DDA Consultant Advice Memo

To: Taronga Zoo – Kristine Marshall
From: Paul O’Shannassy
Date: 07.04.2021
Project: Taronga – Upper Australia Refurbishment
MSA Ref: MSA2080_DDA_Memo1

Re: Upper Australia SSDA Modification - Accessibility (DDA) review of revised dingo exhibit pathway & southern link

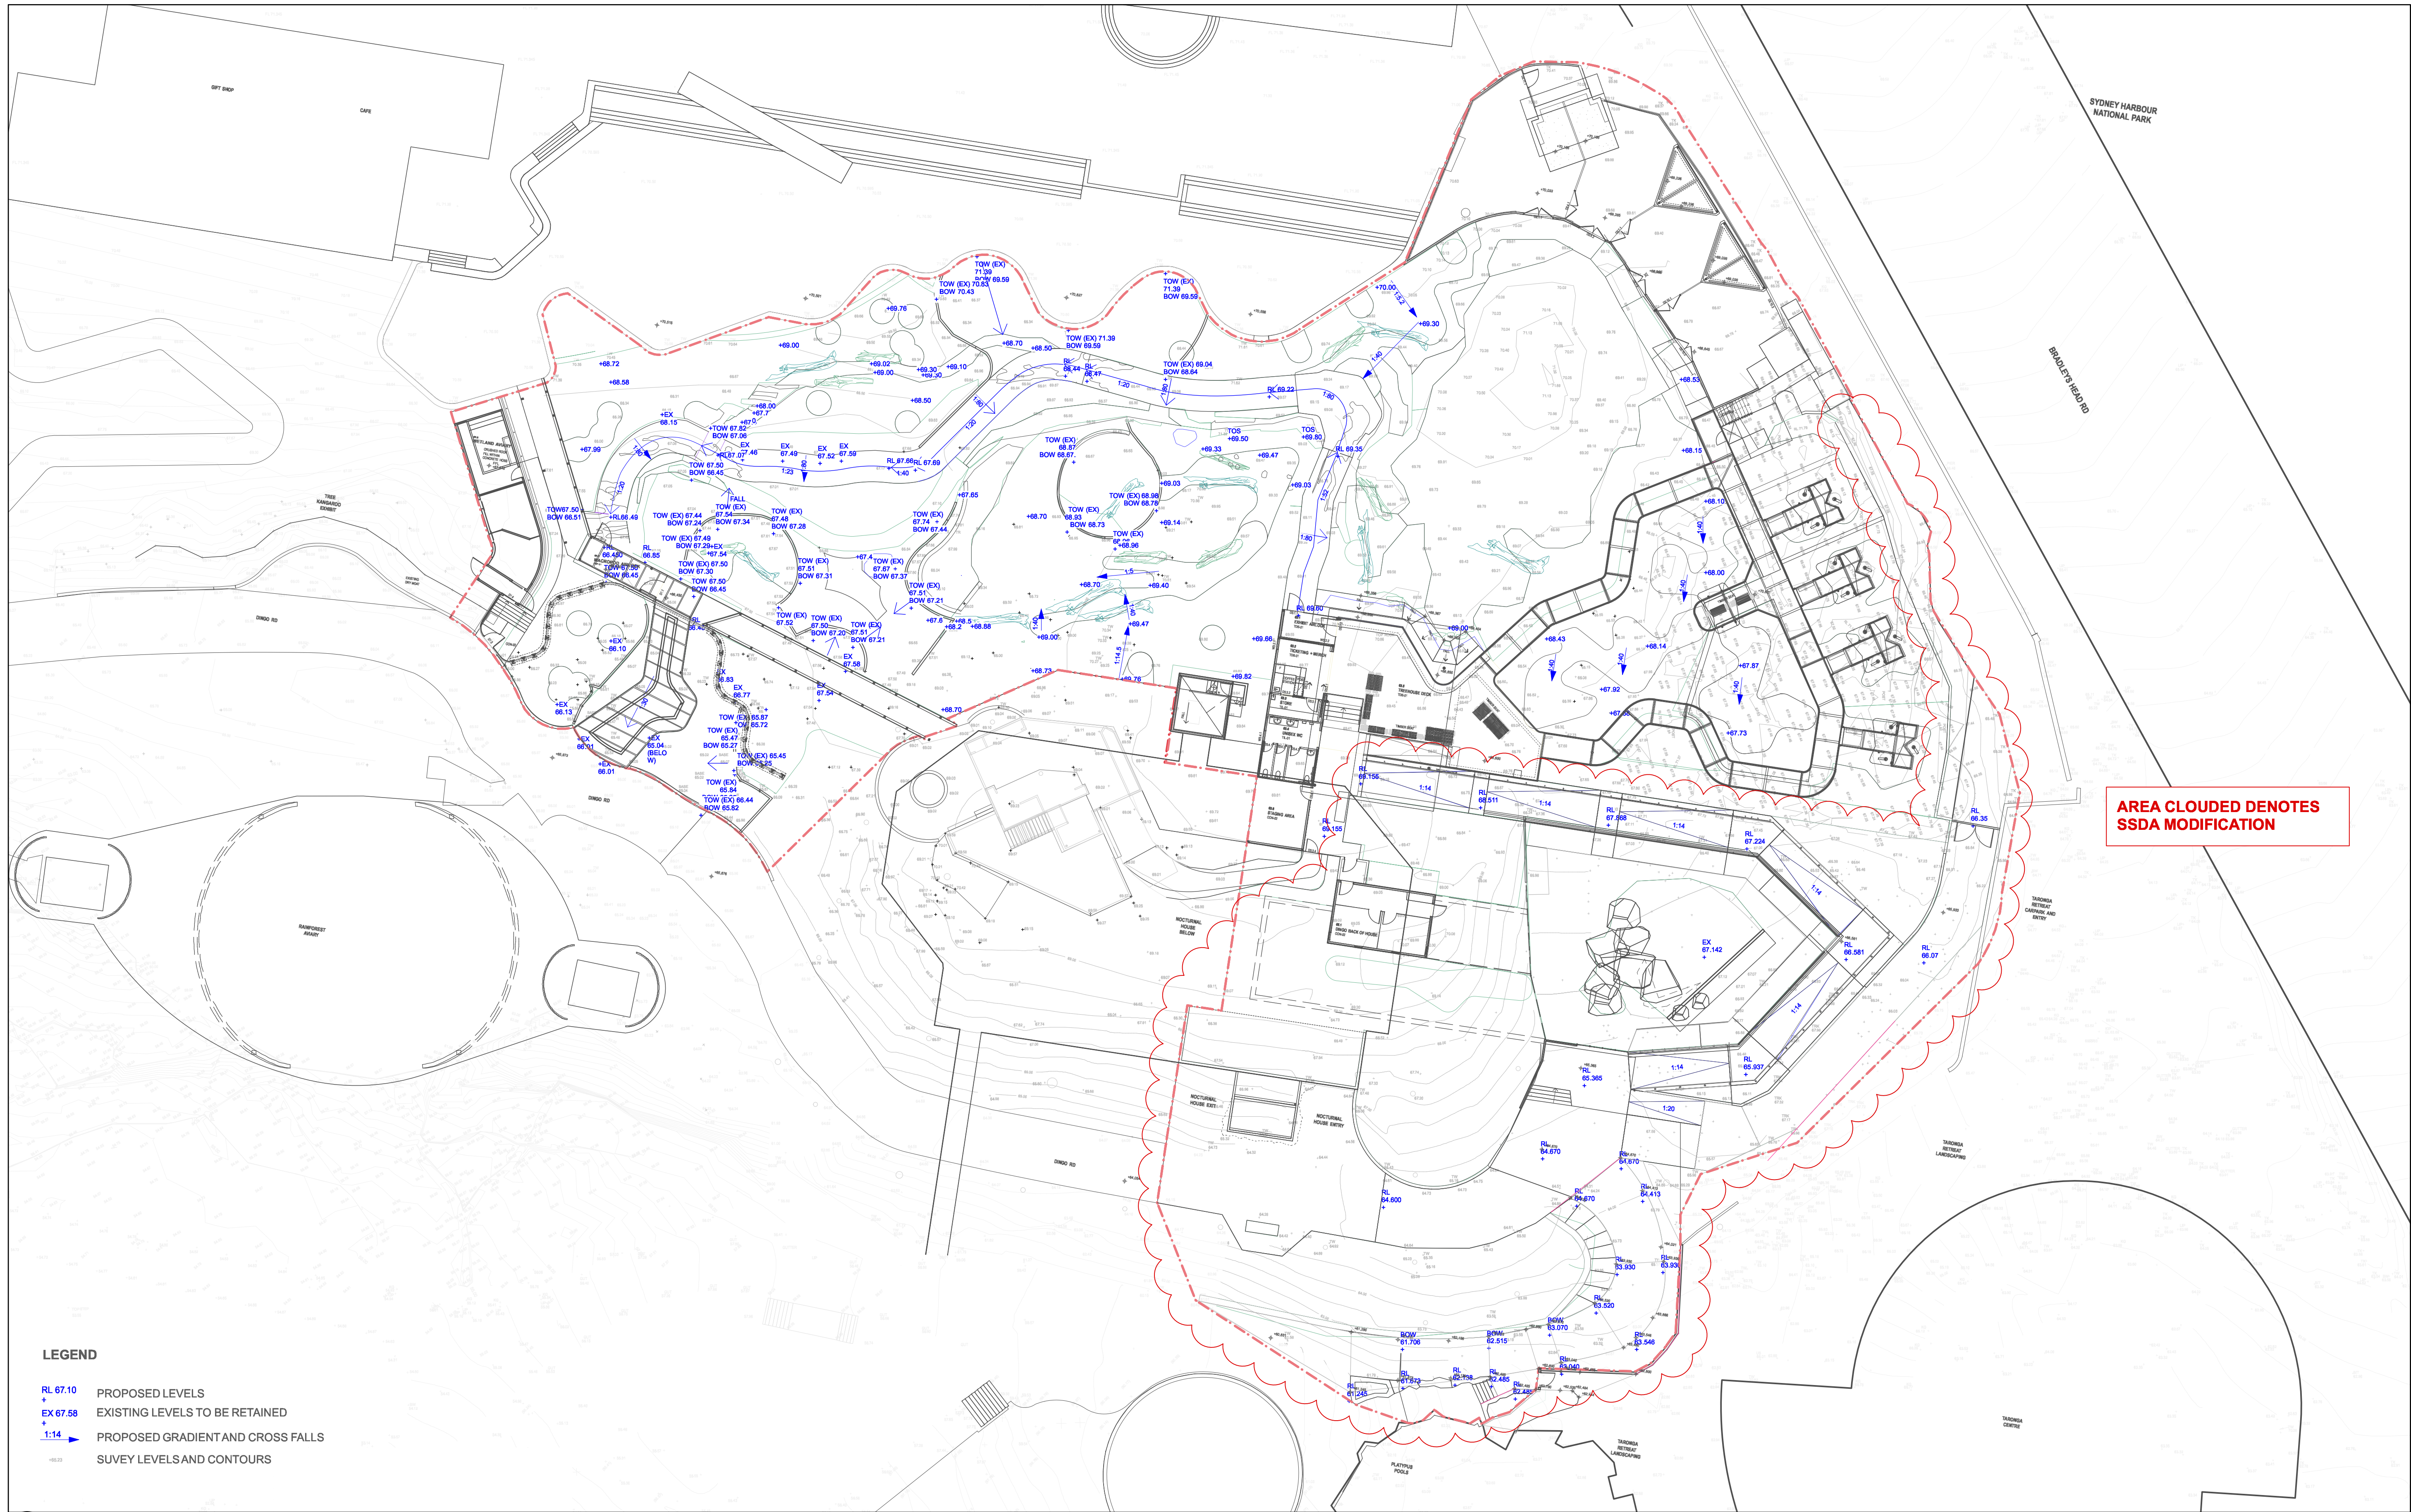
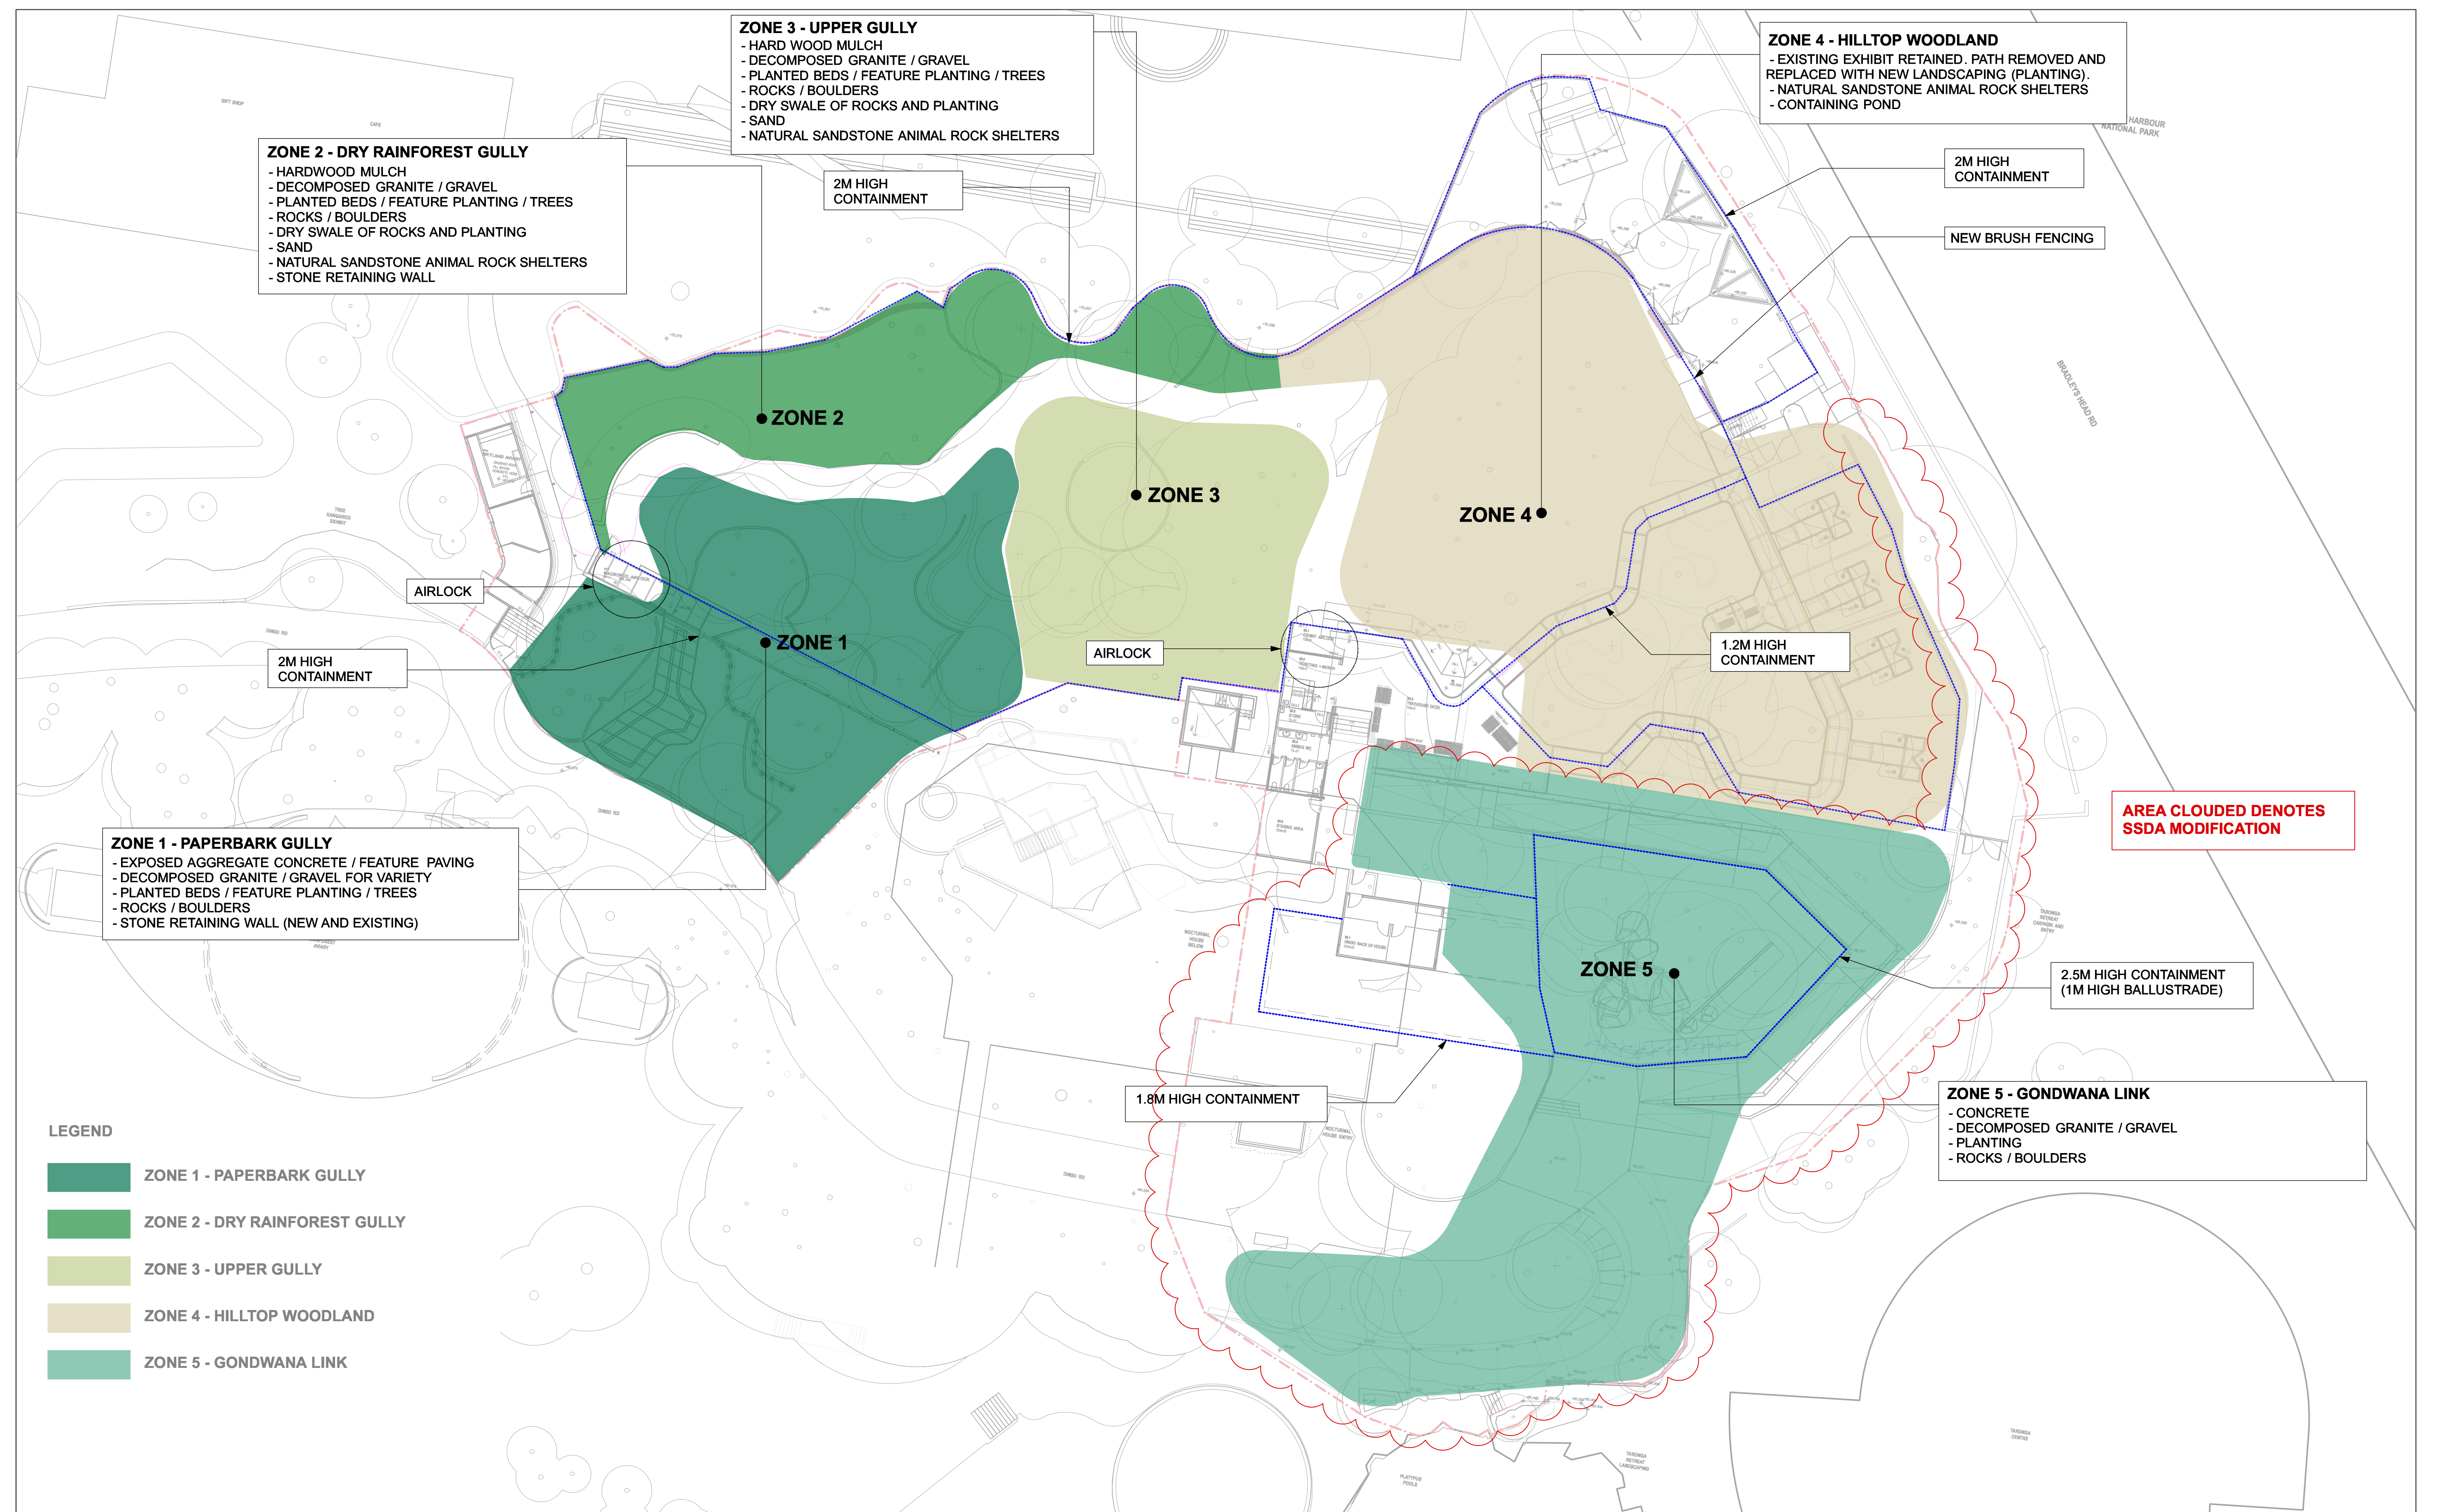
Dingo Exhibit Pathway – Compliance Comments & Recommendations

The pathway is directly associated with the dingo exhibit and although not forming a 'building' (for the purposes of BCA compliance) is recommended by MSA to be 'accessible' (i.e. generally complying with AS1428.1).

The pathway primarily comprises a series of ramps and landings (with additional stairs and a 1:20 'walkway' provided to the south).

The location, grades and dimensions of the ramps (& stairs/walkway) are generally compliant with AS1428.1 & therefore deemed 'accessible'.

Further details would typically be provided during detailed design stage to include:

- Handrails – accessible handrails required to both sides of stairs and ramps
- Kerb rails/Kickplates – required to the sides of ramps & walkways
- Tactile Ground Surface Indicators (TGSI's) – required to top and bottom of ramps and stairs (noting that TGSI's are not required to mid landings where a continuous handrail is provided).
- Stairs details - solid risers & contrasting non-slip nosing strips
- Floor surfaces (of ramps and landings) – to be non-slip and traversable by wheelchair

Southern Link

The works proposed to the existing 'southern link' generally involved the widening & repositioning of the path resulting in an overall shallower grade.

It is noted that this area serves as a pedestrian link between levels of the zoo, but is not considered to be directly associated with a particular 'building' and as such not considered to attract the accessibility requirements of the BCA or 'Access to Premises Standards' (similar to a public footpath in this regard).

Notwithstanding, the proposed works will improve general accessibility including pram access.

General (advisory) recommendations to be considered include:

1. Provision of handrails, kerbrails
2. Provision of slip resistance path surface
3. Seating for rest
4. Lighting above the pathways
